ADDENDUM TO NOBLE DENTON MARINE SERVICES REPORT TO SPIRIT ENERGY REPORT REVIEW OF MARINE HAZARDS (DECEMBER 2018)

TECHNICAL NOTE

Date:	14 th December 2018	Ref:	TN – 777	Rev: 0
Project No:	10074959 Task 60	Client:	Spirit Energy	
Attn:	Max Rowe			
Author:	Robert Sinclair	Checked:	Sujit Viswanathan	
Subject:	Addendum to Report A 13423 Rev 3 – Review of Marine Hazards – Hornsea 3 Windfarm

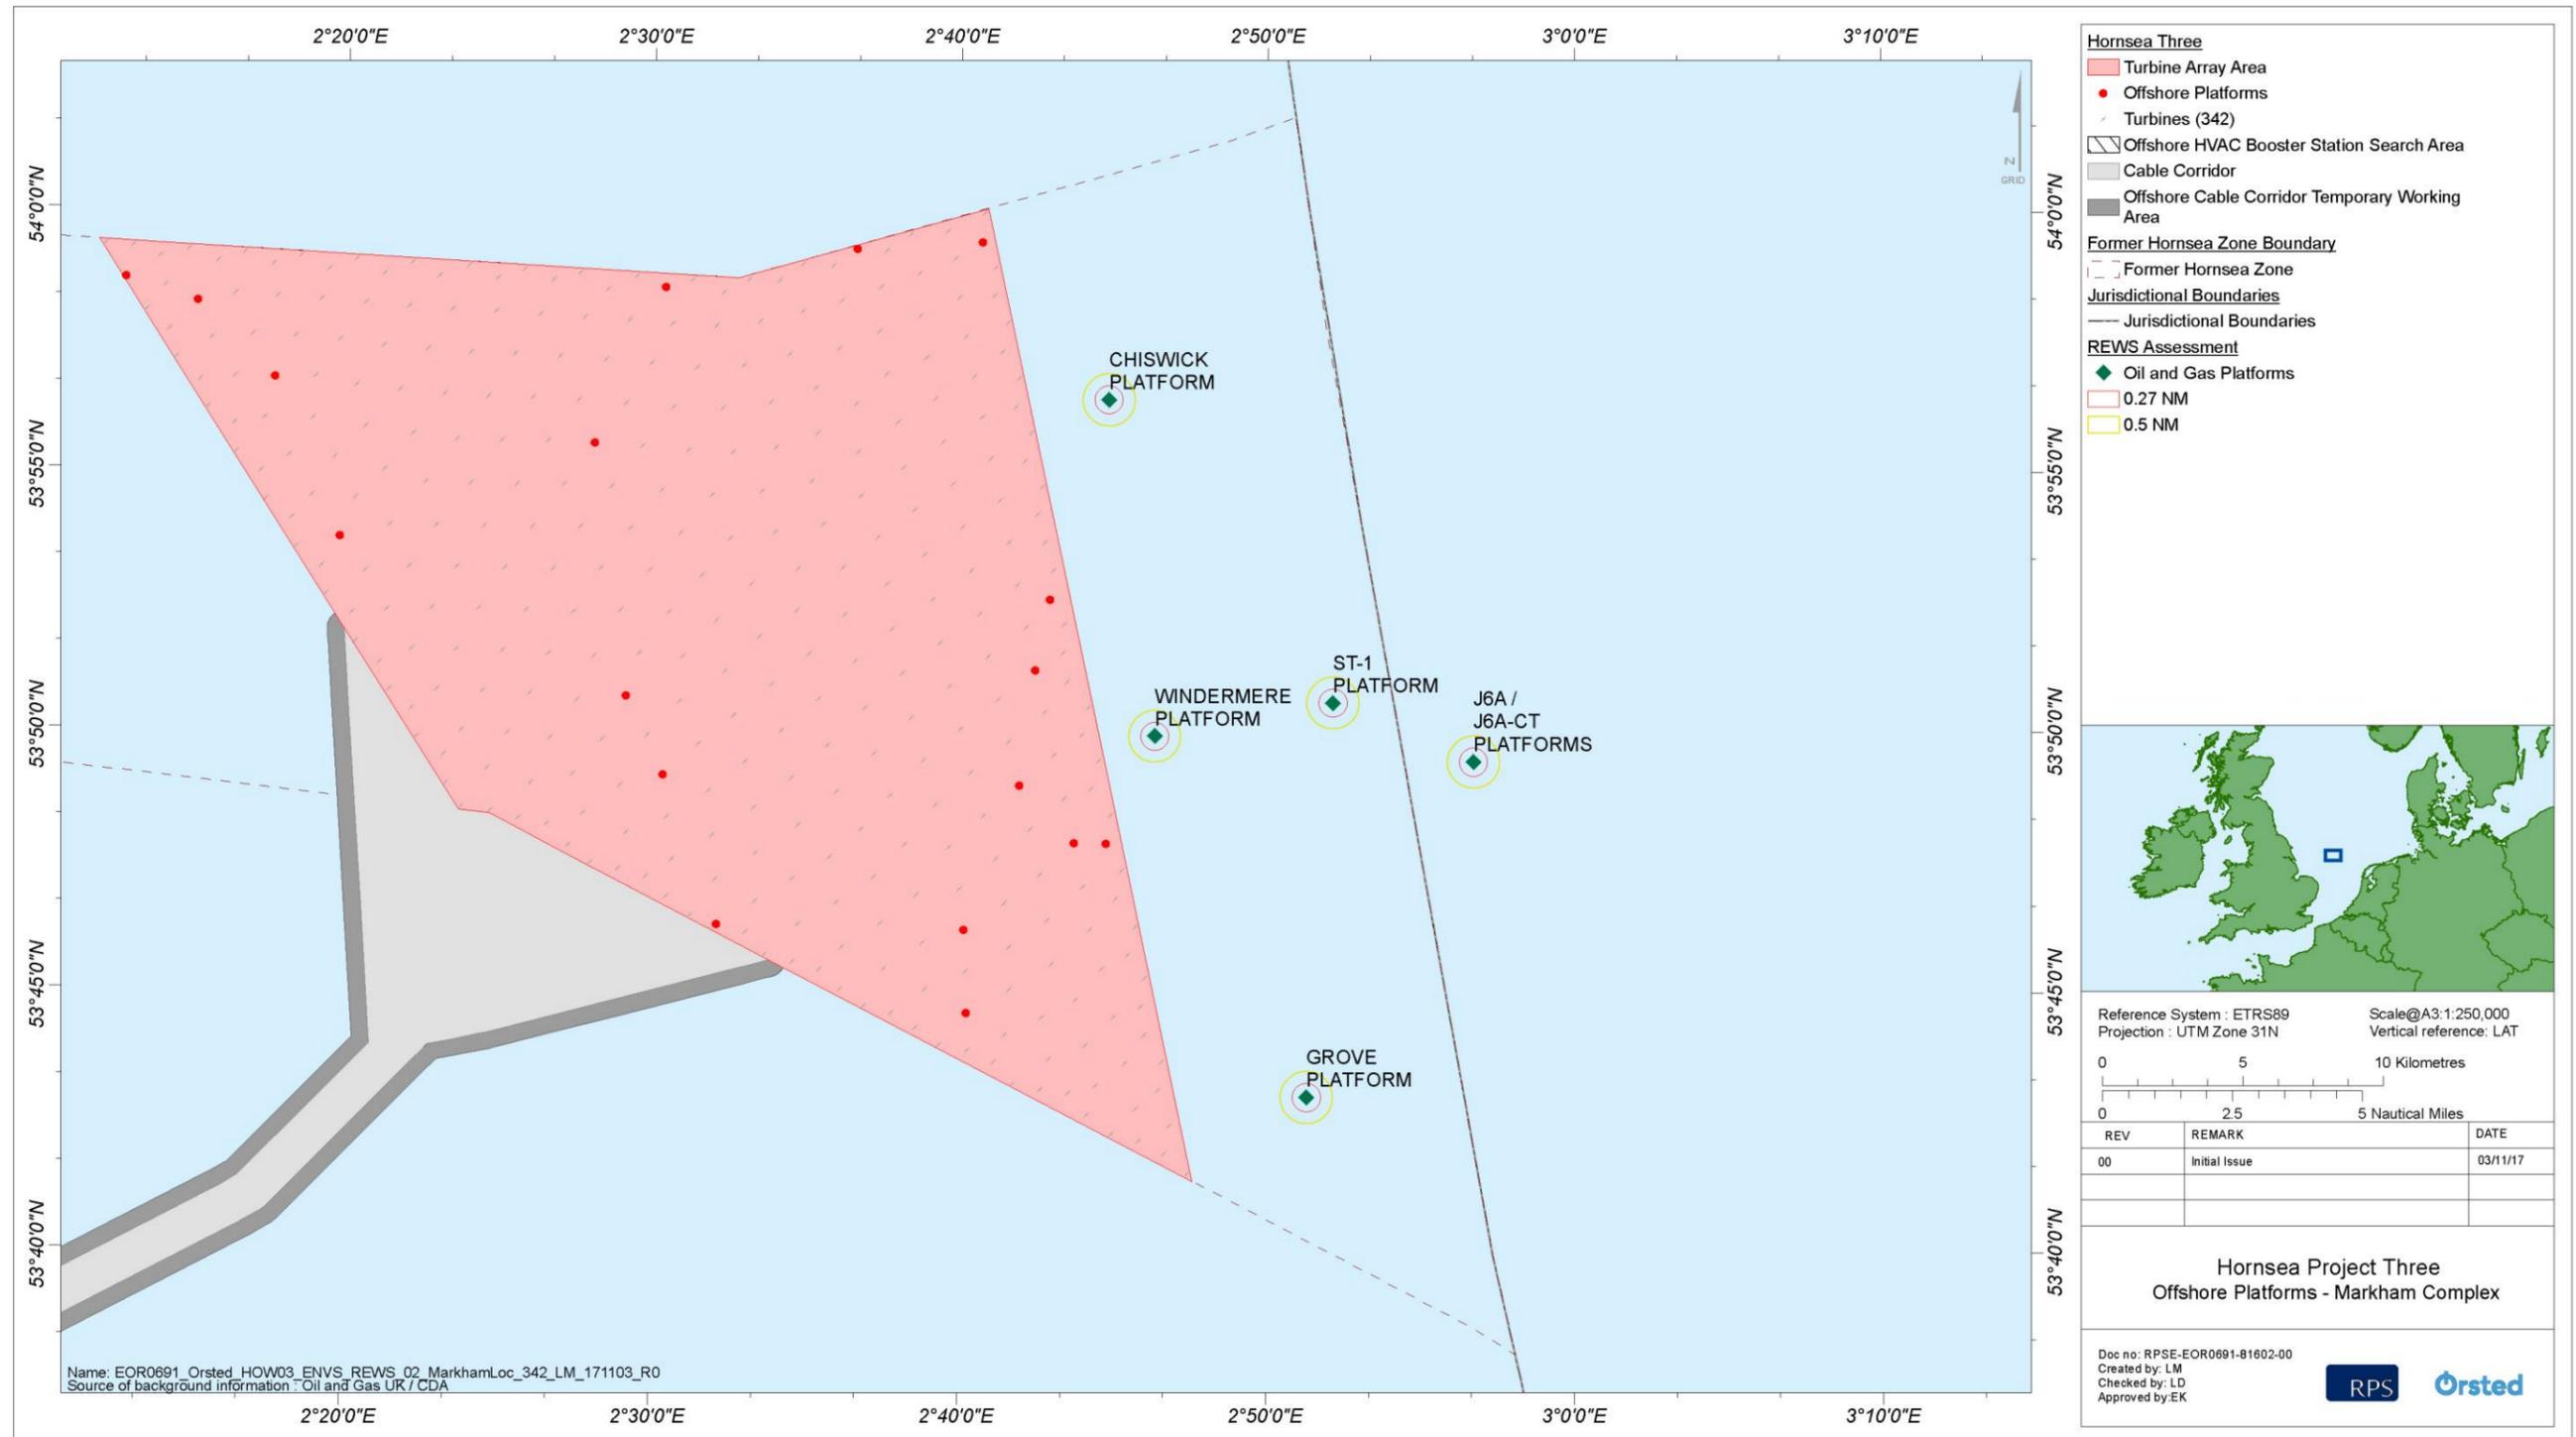
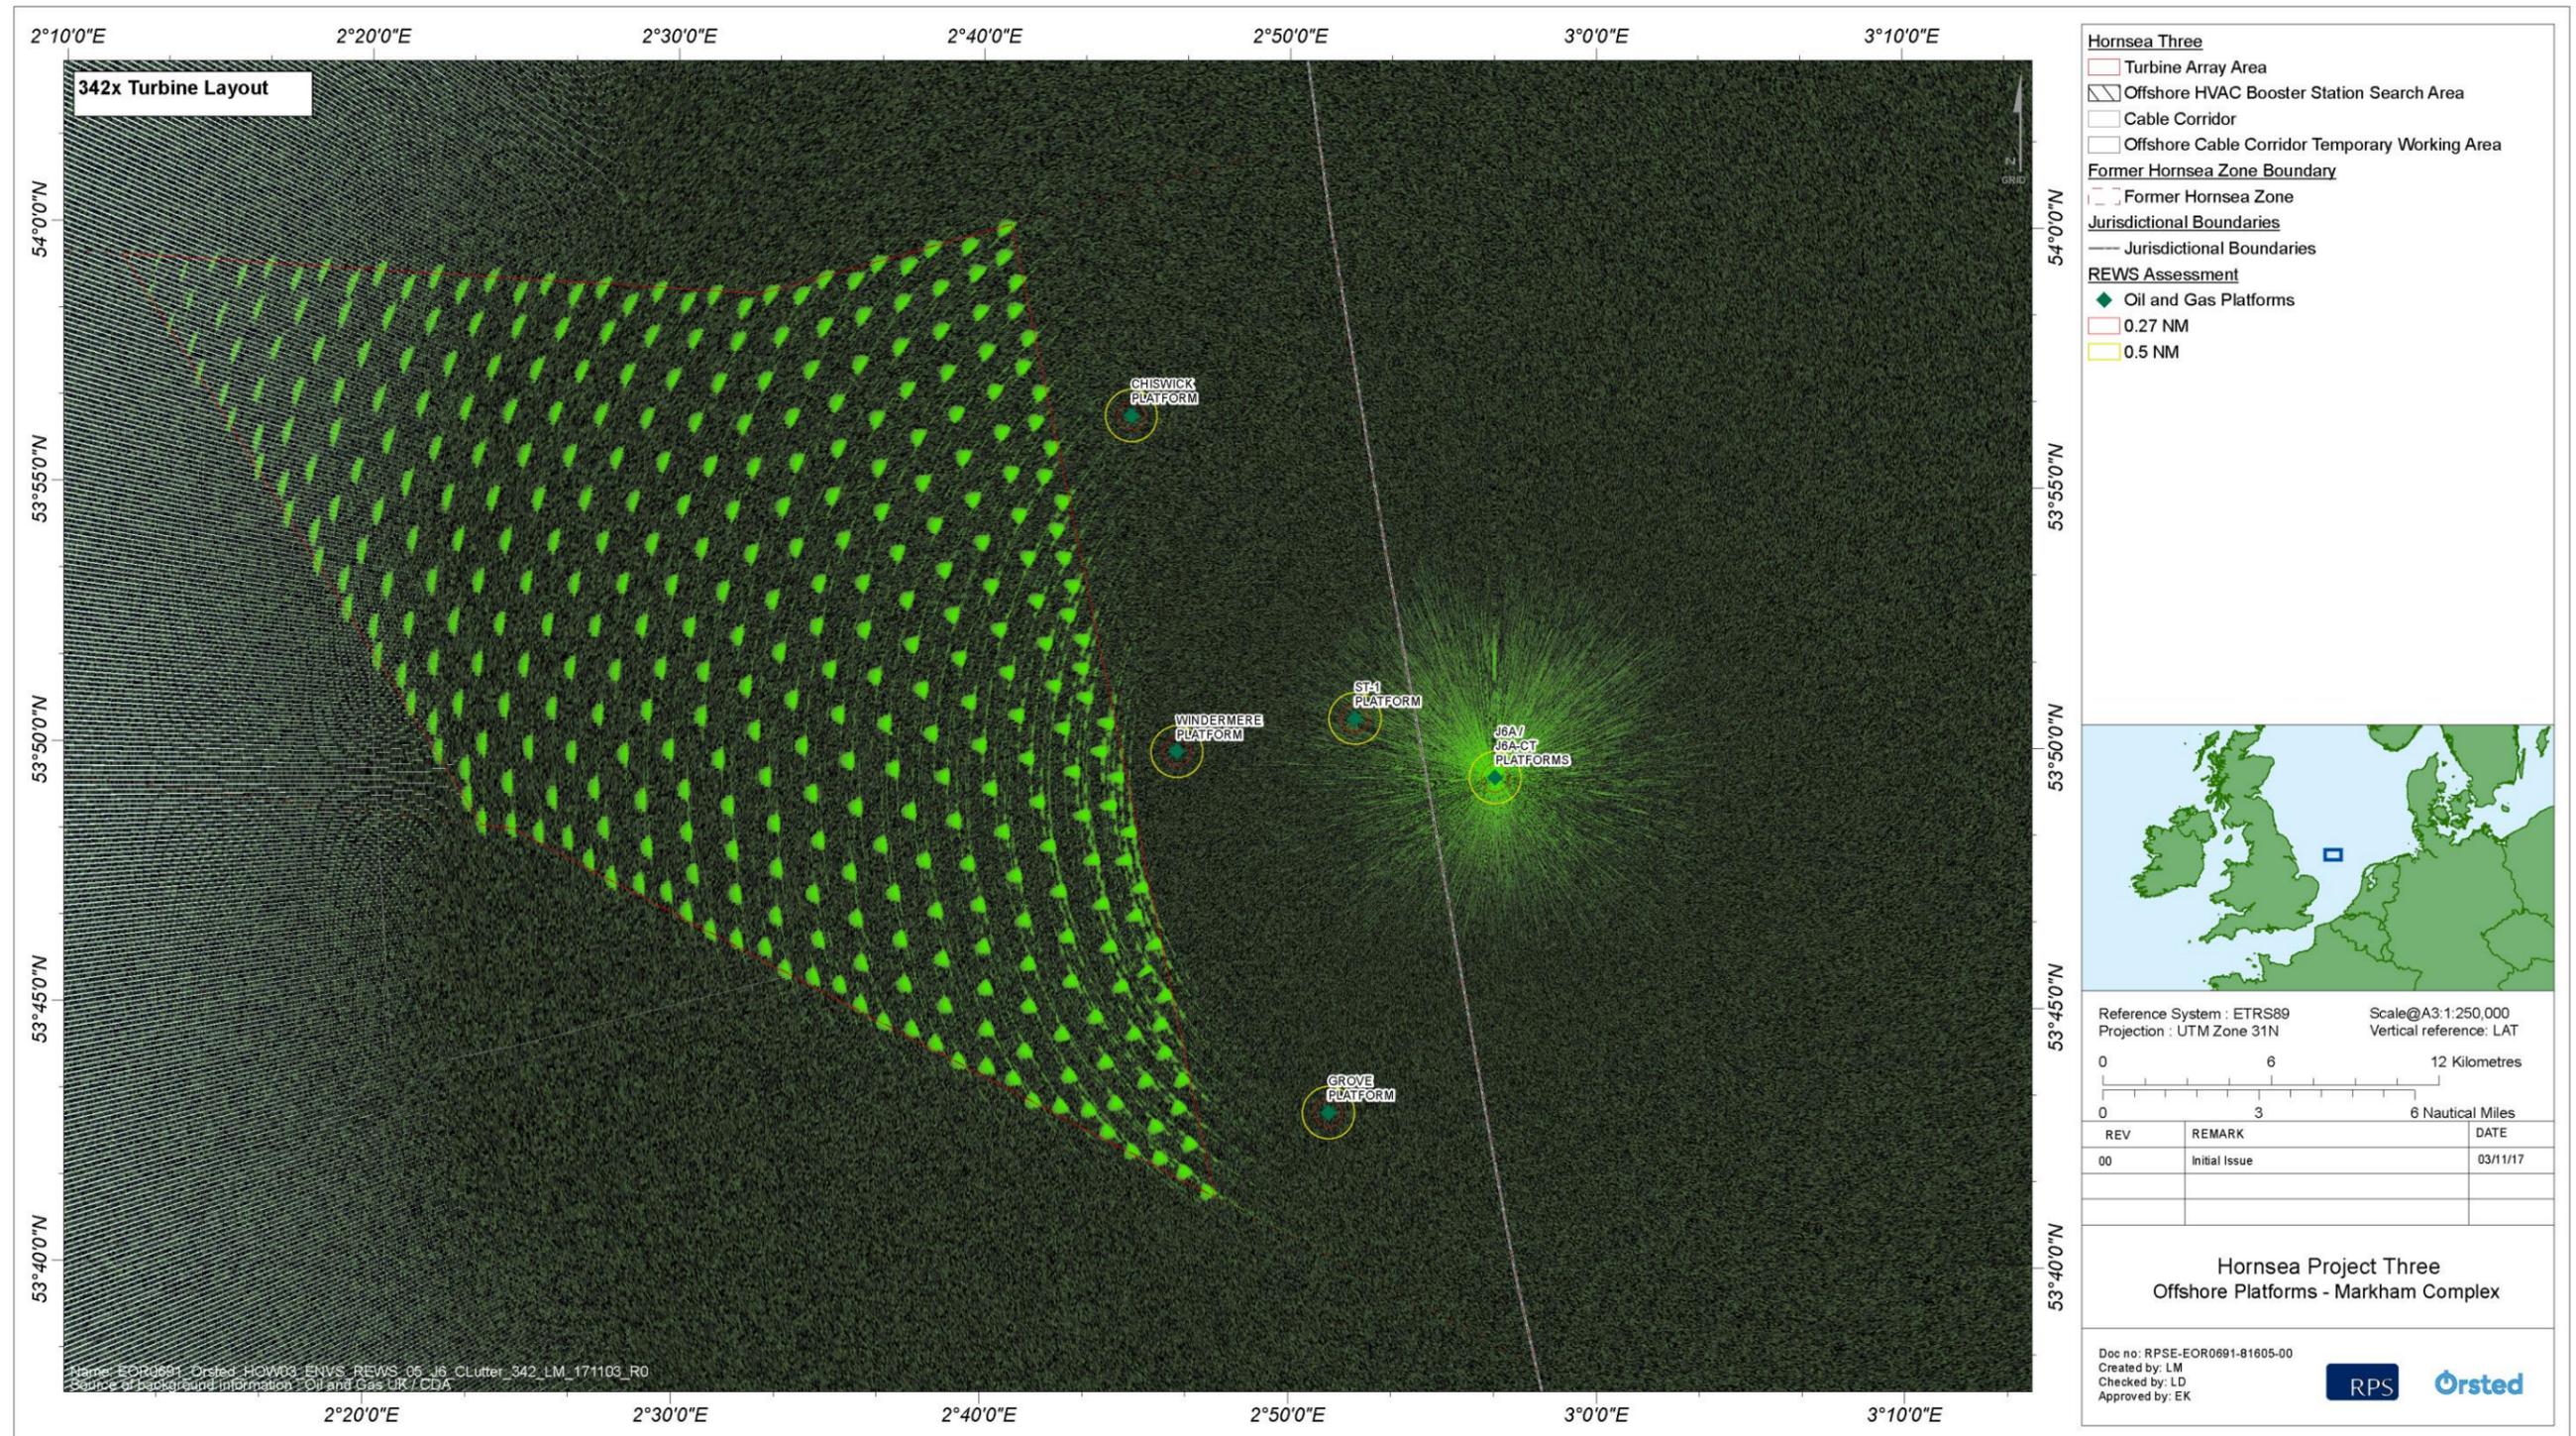
We also note that recent correspondence between Spirit Energy and Ørsted indicate Ørsted's belief that platform J6A has a RACON and AIS that would not be affected by the turbines in the array. Whilst we generally agree with this assessment in relation to the RACON and AIS, platform J6A also has, but as its primary means of detecting approaching and errant vessels (towards itself and its satellite platforms of Grove and Chiswick NUIs), an ARPA (Automatic Radar Plotting Aid) system which we believe will highly likely be affected in its practical operation by the planned array. We can also confirm that, in fact, J6A does not have a REWS system as outlined in the Applicant's documentation. There is, therefore, a further gap in the Applicant's risk assessment and this too is a real concern for safe vessel movement close to the Spirit Energy offshore infrastructure.
